Date: 14 July 2026

Below are the comments of Derbyshire County Council in response to the application for non-material changes relating to Oaklands Farm Solar, EN010122.

## Appendix F: Substation Details

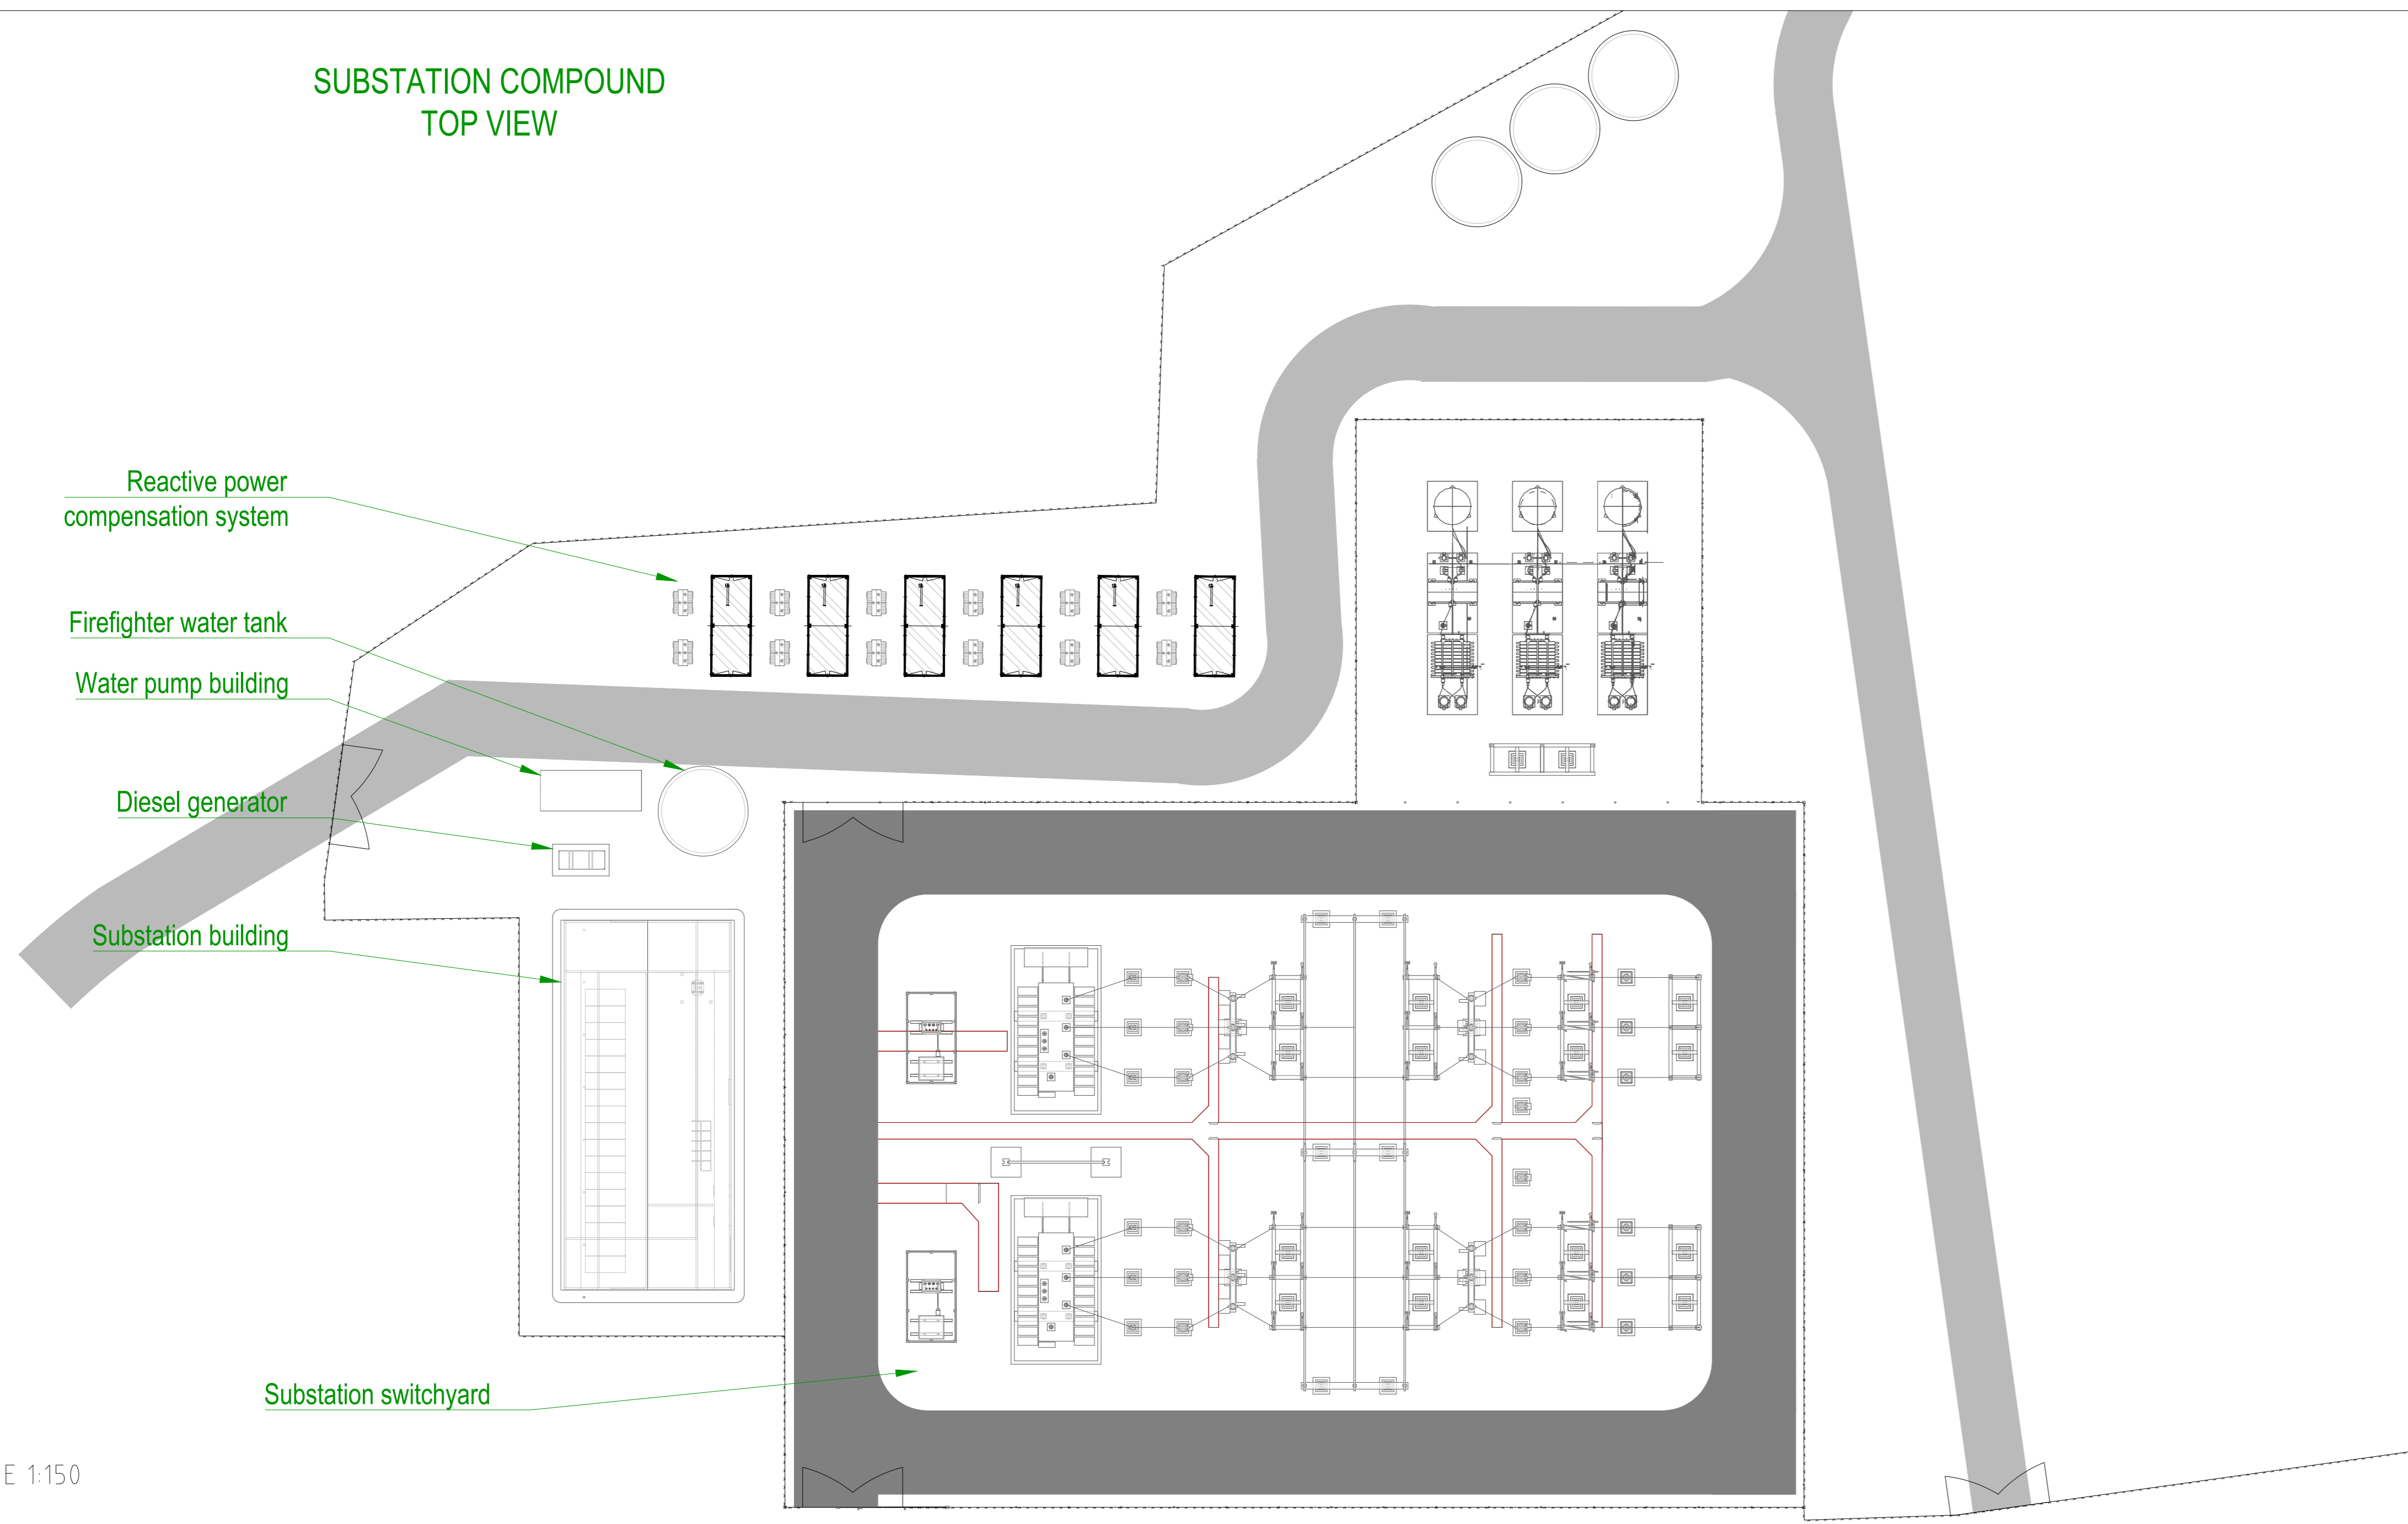
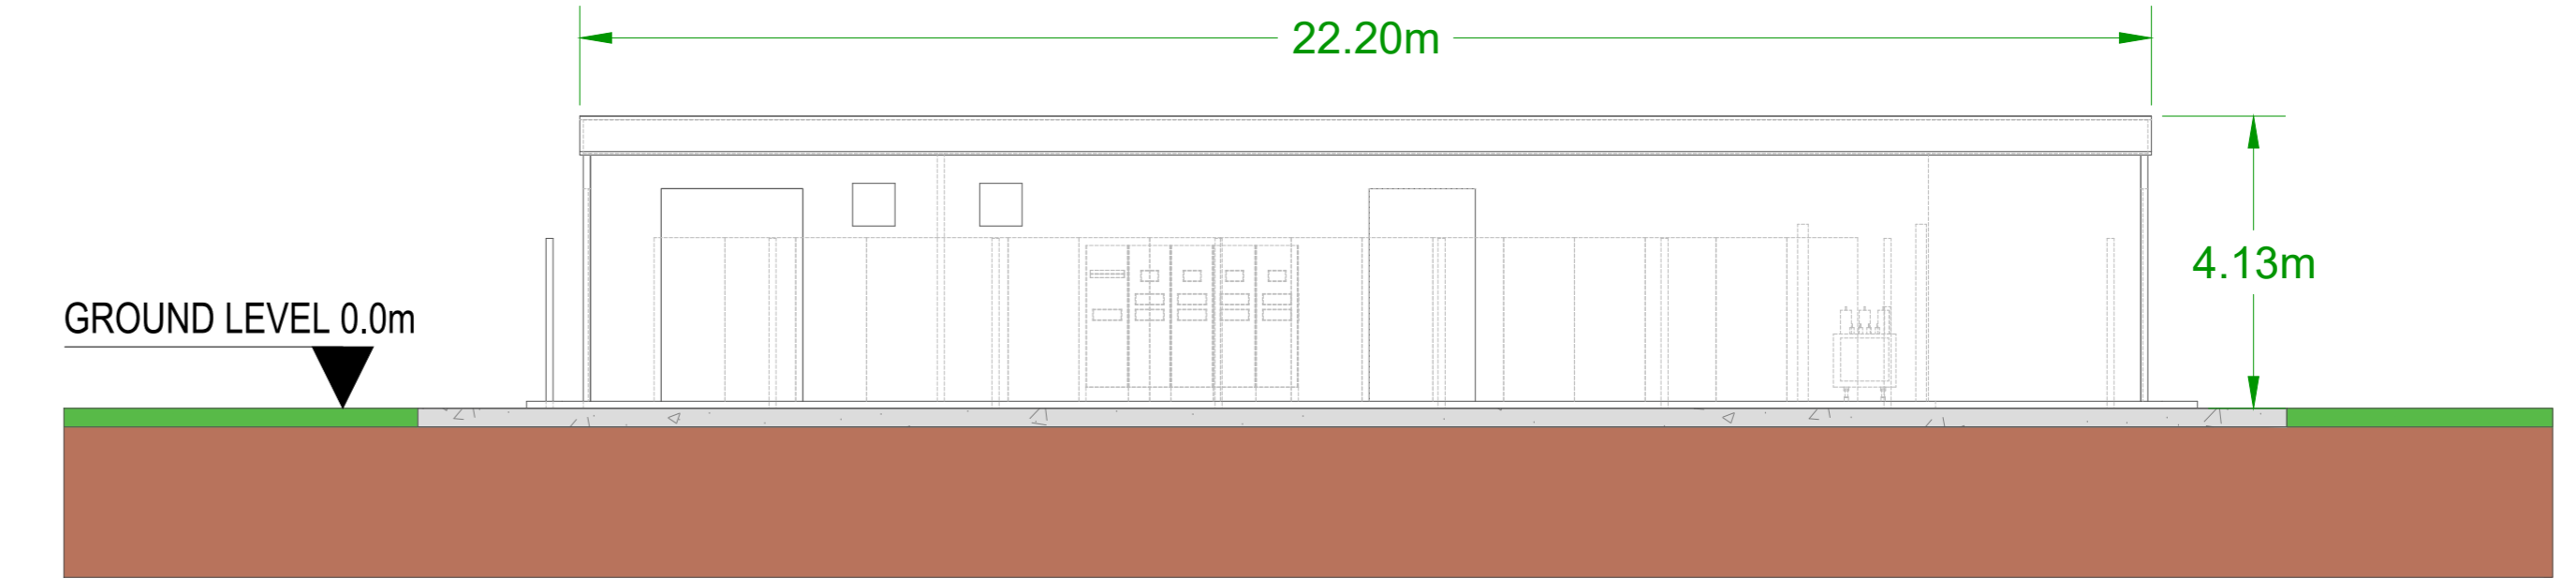
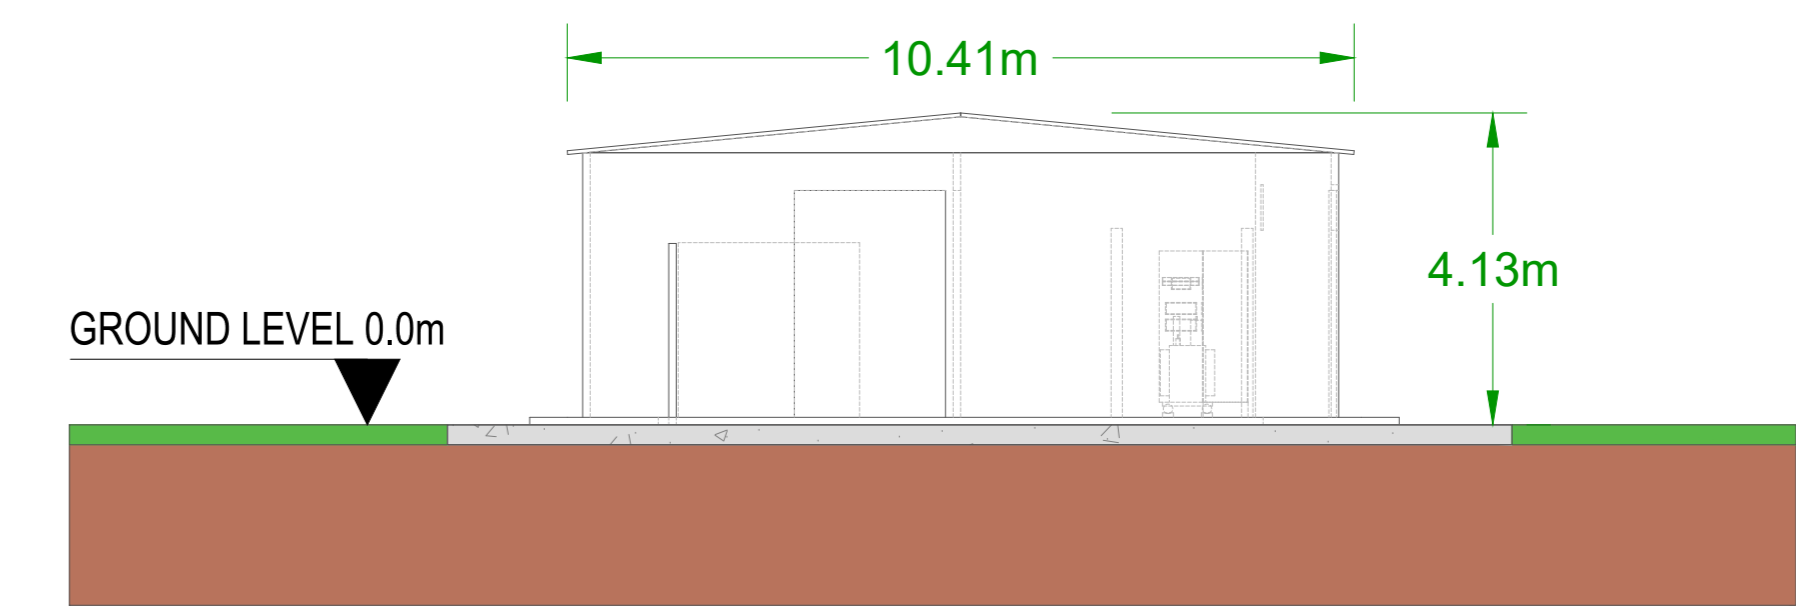
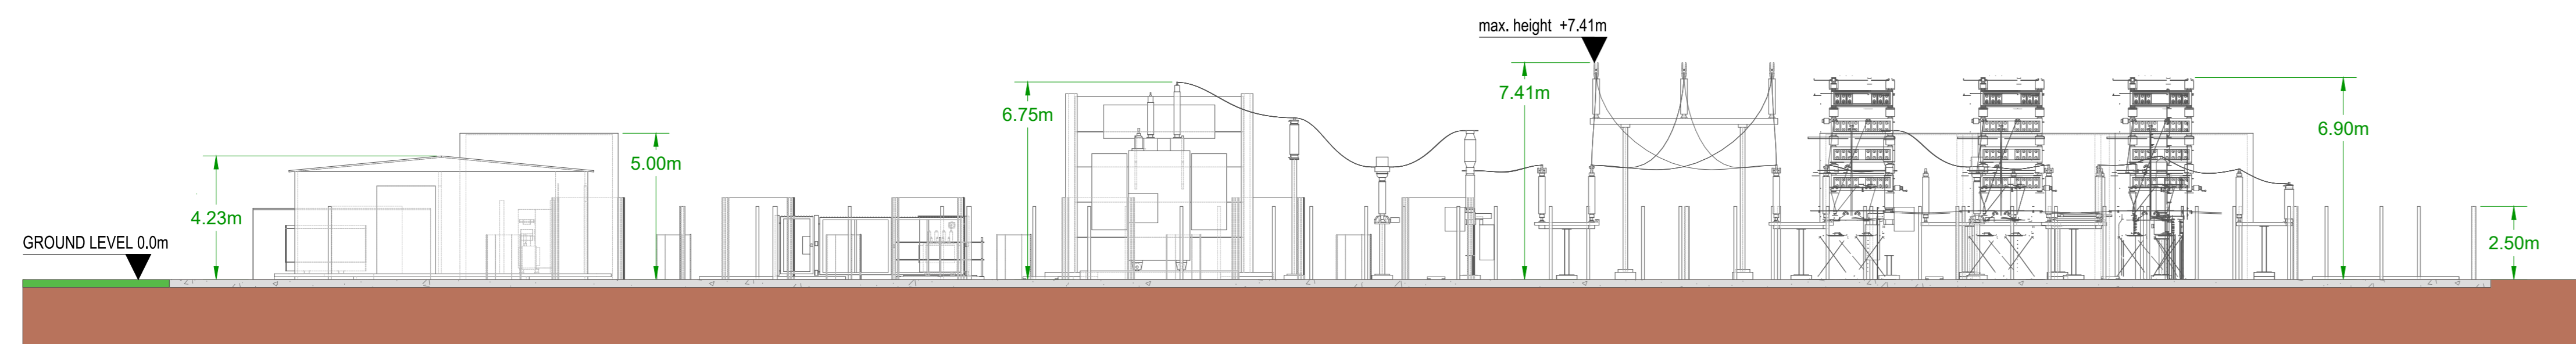
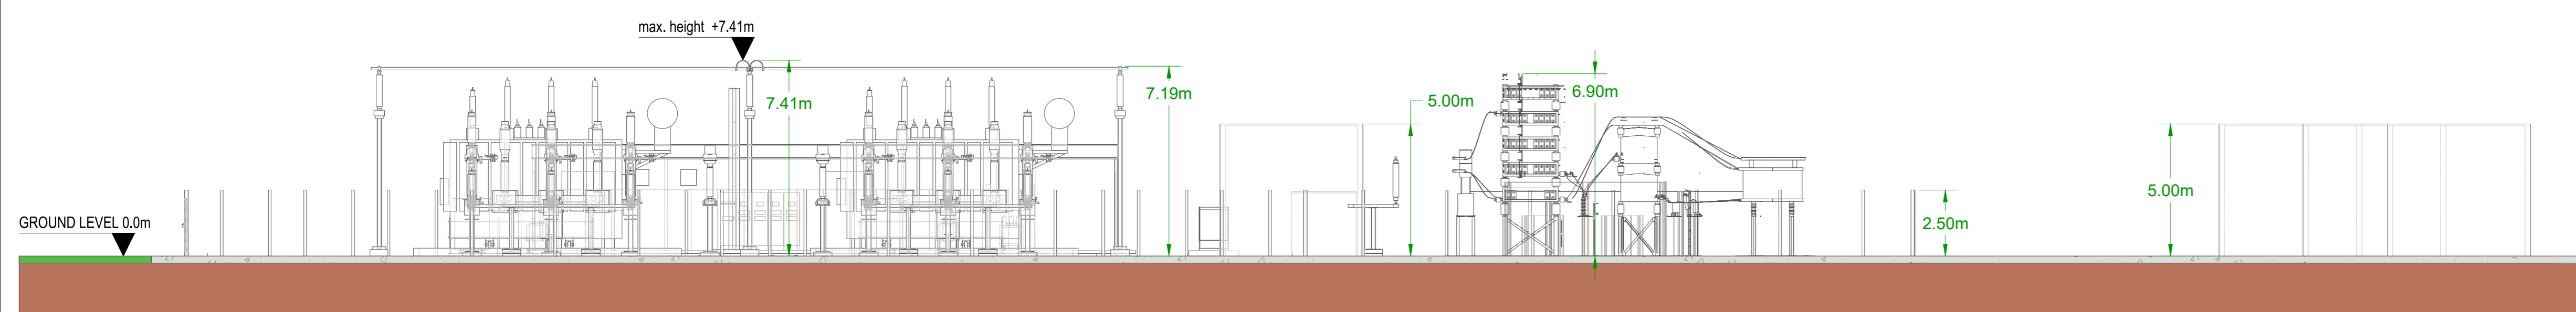
Change 4 – Substation - The original parameters allowed for a maximum dimension of 7.2m x 5.3m x 3.7m (length, height, width) for the substation transformer but does not specify if this comprises the fully assembled transformer with the additional electrical paraphernalia attached to the main body of the transformer. Therefore, for clarity and avoidance of doubt

the parameter is now proposed to be 8.3m x 6m x 5m (length, height, width) which represents the maximum parameters of the substation transformer fully assembled, including its additional electrical paraphernalia. The height of the assembled transformer remains below the tallest part of the substation which is the Overhead Busbar at a height of 7.4m. In addition, the concrete blast wall is to be increased from 5.2m in height to 6.3m for safety reasons.

In addition, the foundation depths of the Welfare Unit and Storage area are to increase from 0.1 to 0.6m and the foundation depth of the statcom will increase from 50mm to 1m.

While it is accepted that the changes proposed to the parameters of the substation are for clarity, the increase in height of the blast wall, by 1.1m, and in increase in depth of the foundations are considered material, particularly in light of the importance placed on visual impacts, land drainage and the potential to return to site to agricultural use on decommissioning during the EiA.
